From: Raymond Cole <Raymond.Cole@arun.gov.uk>
Sent: 29 April 2021 20:35
To: Planning.Responses <Planning.Responses@arun.gov.uk>
Subject: FW: P/132/20/RES Land at Hook Lane

From: paul collins [REDACTED]
Sent: Friday, March 19, 2021 3:52 PM
To: 'Karl Roberts' <Karl.Roberts@arun.gov.uk>; 'Neil Crowther' <Neil.Crowther@arun.gov.uk>; 'Raymond Cole' <Raymond.Cole@arun.gov.uk>
Cc: 'Cllr. Hugh Coster' [REDACTED]; 'Cllr. Tony Dixon' [REDACTED]; 'Cllr. David Huntley' [REDACTED]; 'Cllr. June Hamilton' [REDACTED]; 'Cllr. Martin Lury' [REDACTED]; 'Cllr. Gill Yeates' [REDACTED]; 'Cllr. Jamie Bennett' [REDACTED]; 'Cllr. Gill Yeates' [REDACTED]; 'Clerk (Aldwick Parish Council)' [REDACTED]
[REDACTED]
Subject: P/132/20/RES - Land North of Hook Lane Pagham

I refer to the outline planning permission granted for this site under reference P/30/19 OUT and its related S106 Agreement dated 2/9/19 and the attached officers reports and minutes of the DCC meeting on 7 August 2019 which decided to grant the OPP on the advice and recommendation of officers despite the serious concerns raised by the members at the time as recorded.

Project	Hook Lane, Pagham
Drawing	Site Layout
Client	Hallam Land
Job no.	HALL200505
Dwg no.	SL01
Author	AS
Status	PLANNING
Client ref.	
Date	June 2020
Revision	A
Scale	1:1000 at A1
Office	Romsey

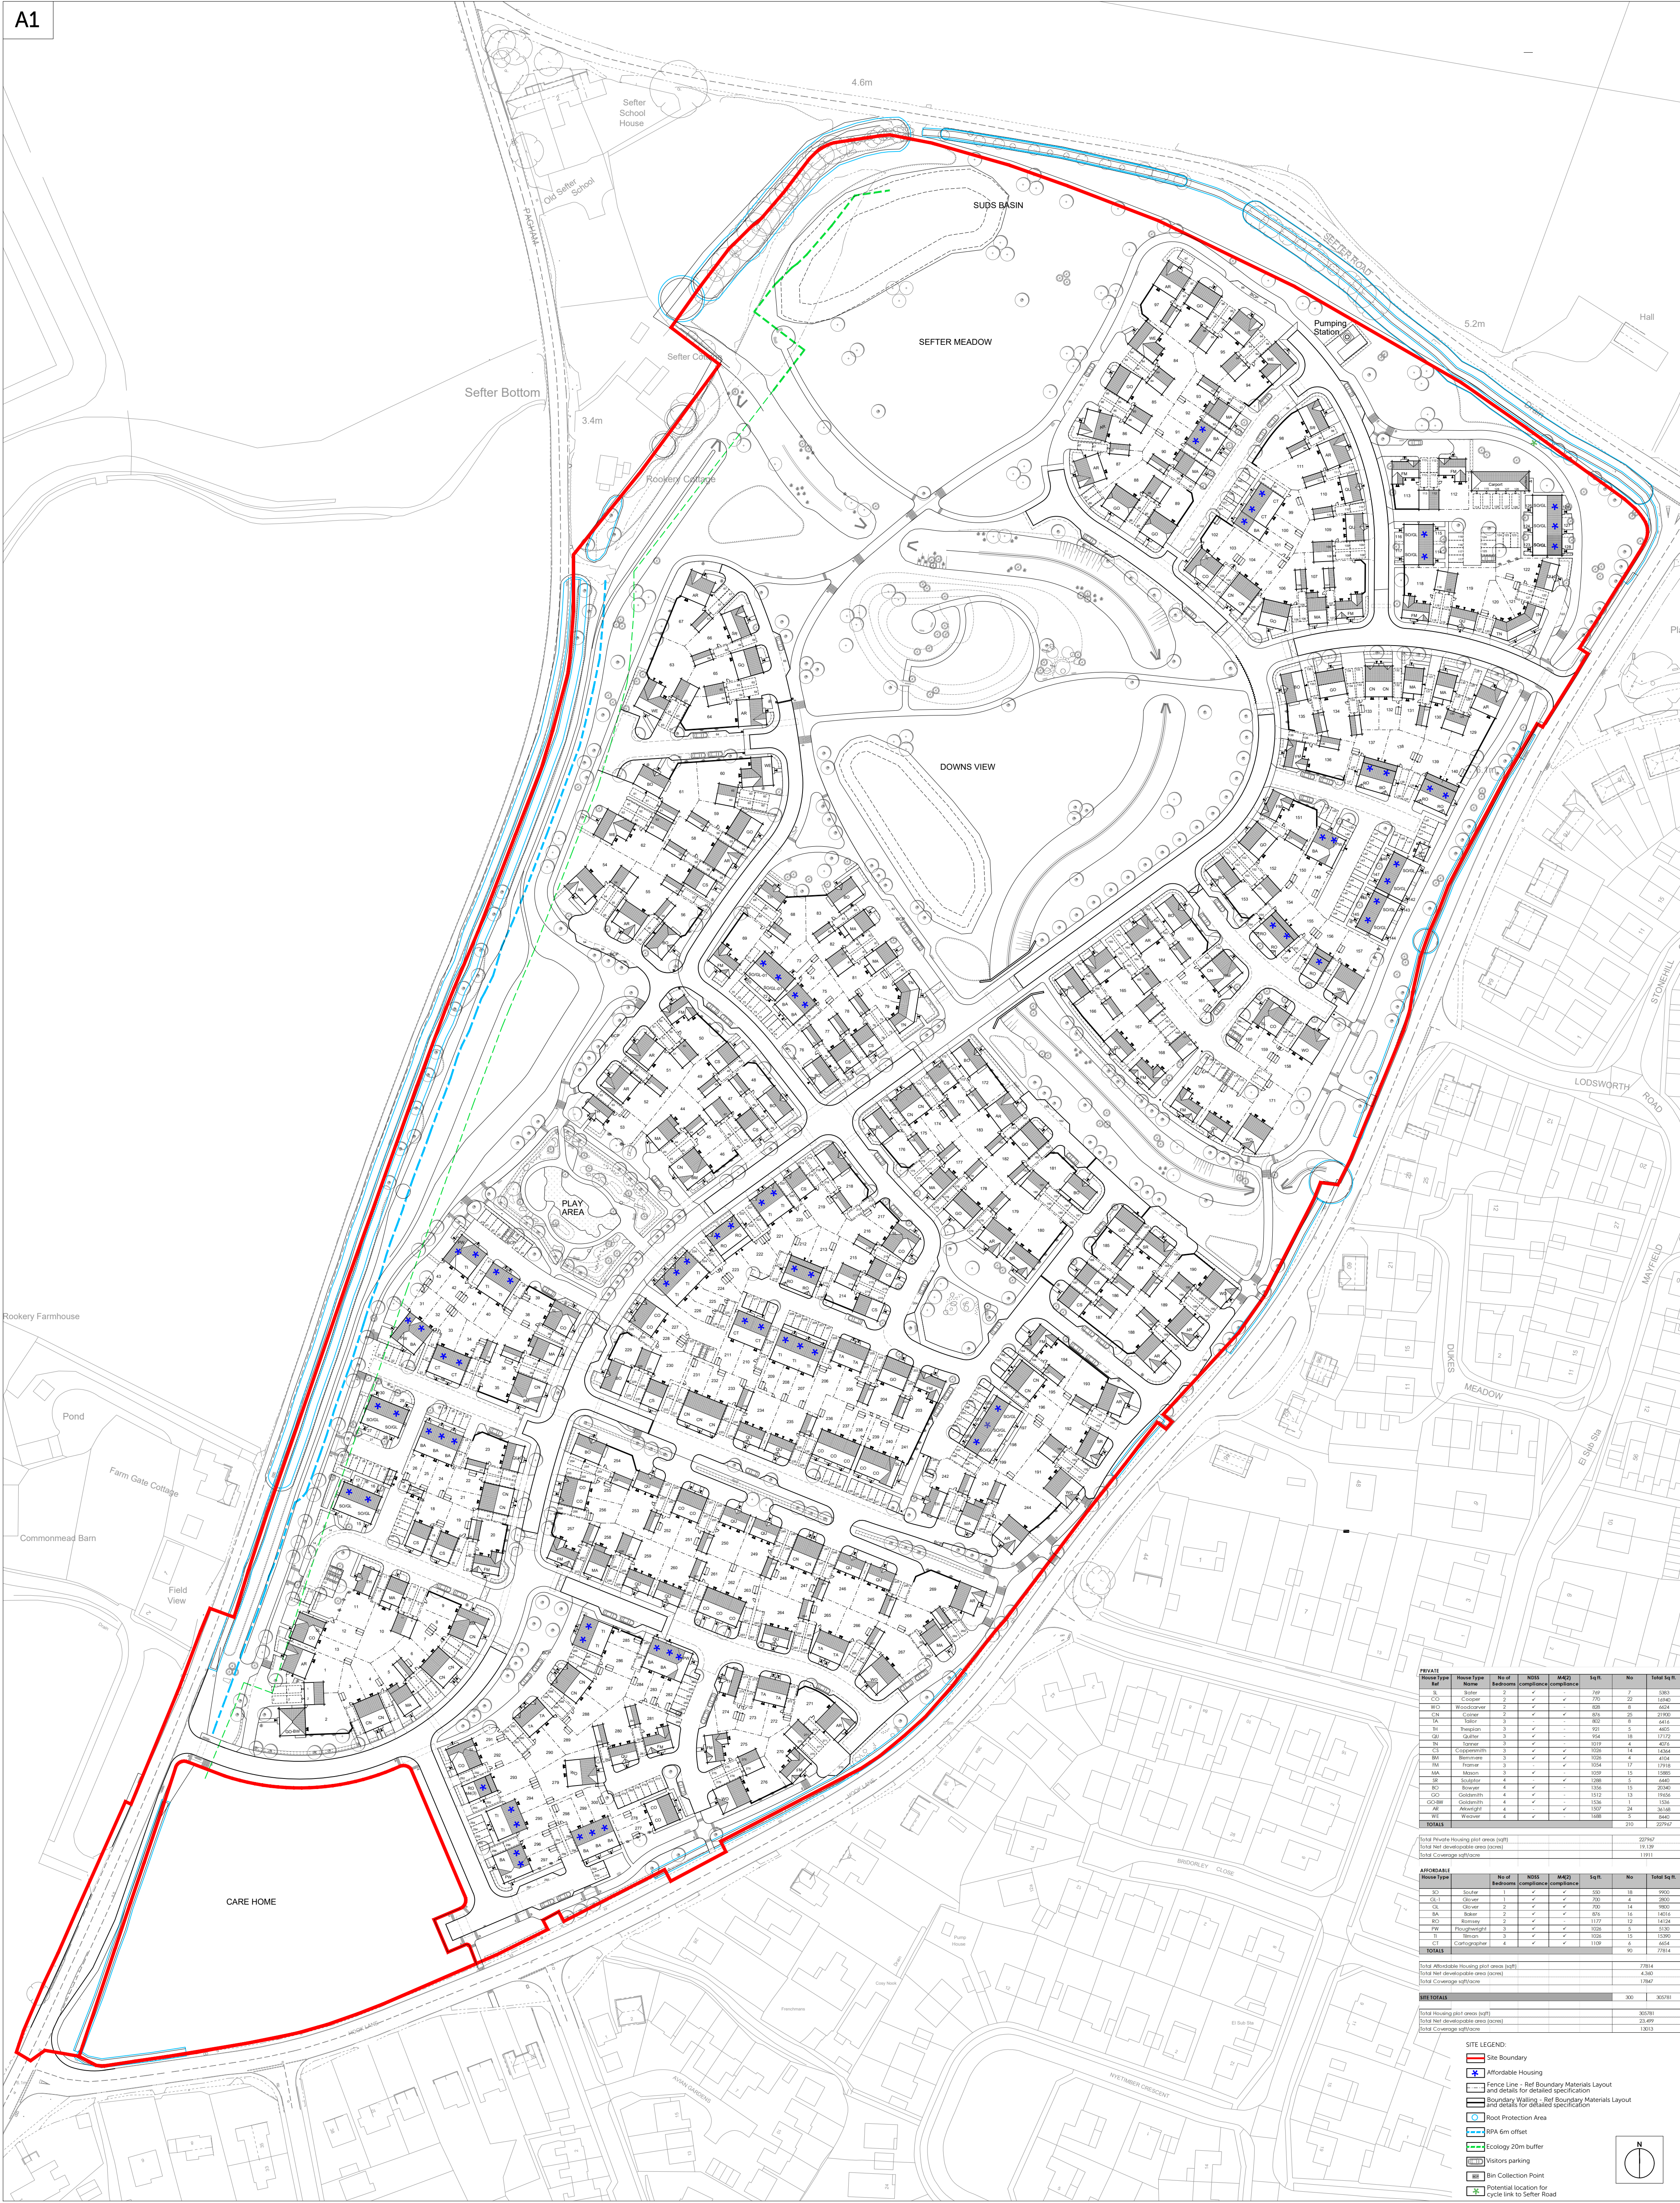
- 2.
3. The proposed layout of the site with 300 houses is an over-intensive use of the site for housing and an unsatisfactory form of development resulting in significant and demonstrable harm to the rural character of this edge of settlement location in conflict with Arun Local Plan policies D SP1, D DM1, LAN DM1, the National Planning Policy Framework (2019) and the National and Arun Design Guides.
